**Consultation Response from KC,
Trees**

2024/91185 Oakroyd Hall, West Yorkshire Fire And Rescue Service Headquarters, Bradford Road, Birkenshaw, BD11 2DY

Variation of condition 2 (plans) and condition 15 (Car Park Management Plan) on previous permission 2022/92681 for variation of conditions 2 (Plans), 3 (CMP), 4 (LEDS), 8 (BEMP) 12 (Drainage), 17 (AMS), 22 (Phase II Intrusive Investigation), 23 (Remediation) on previous permission 2022/91138 for demolition of existing training centre and occupational health buildings, erection of new headquarters including indoor training centre, extension of existing building to form new fire station, extension of car parking and associated landscaping and drainage

Date Responded: 12/06/2024

Drawing Number
 D8808.04.002

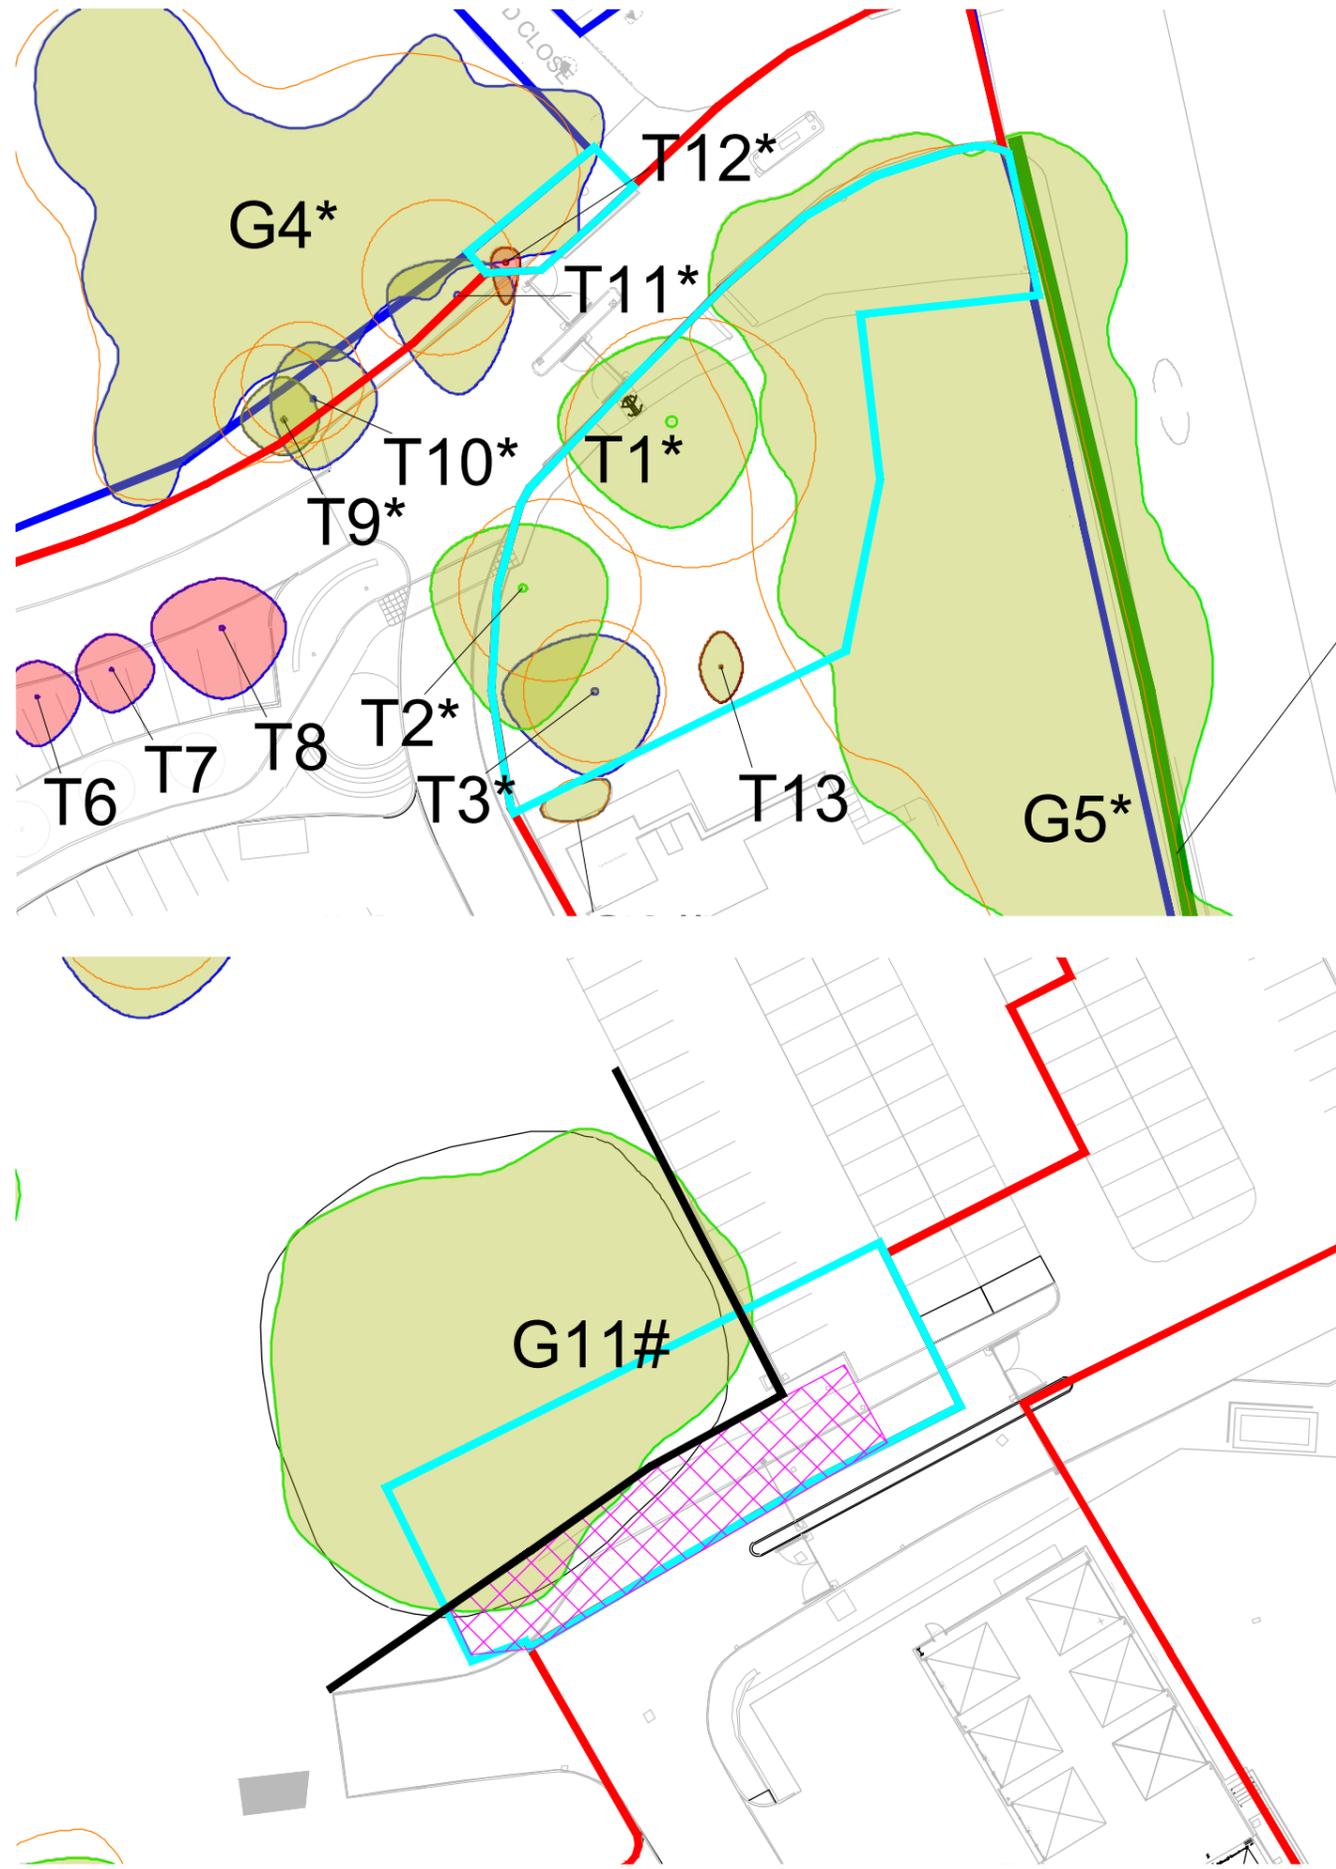
The variations will have virtually no effect on the retained trees as per previous permission. The only trees to be effected is G11 of which there are proposed new curb works within the root protection area. The Arboricultural impact assessment and method statement Addendum sufficiently details how these works will be supervised and hand dig techniques will be used. I am confident this won't result in any further tree loss.
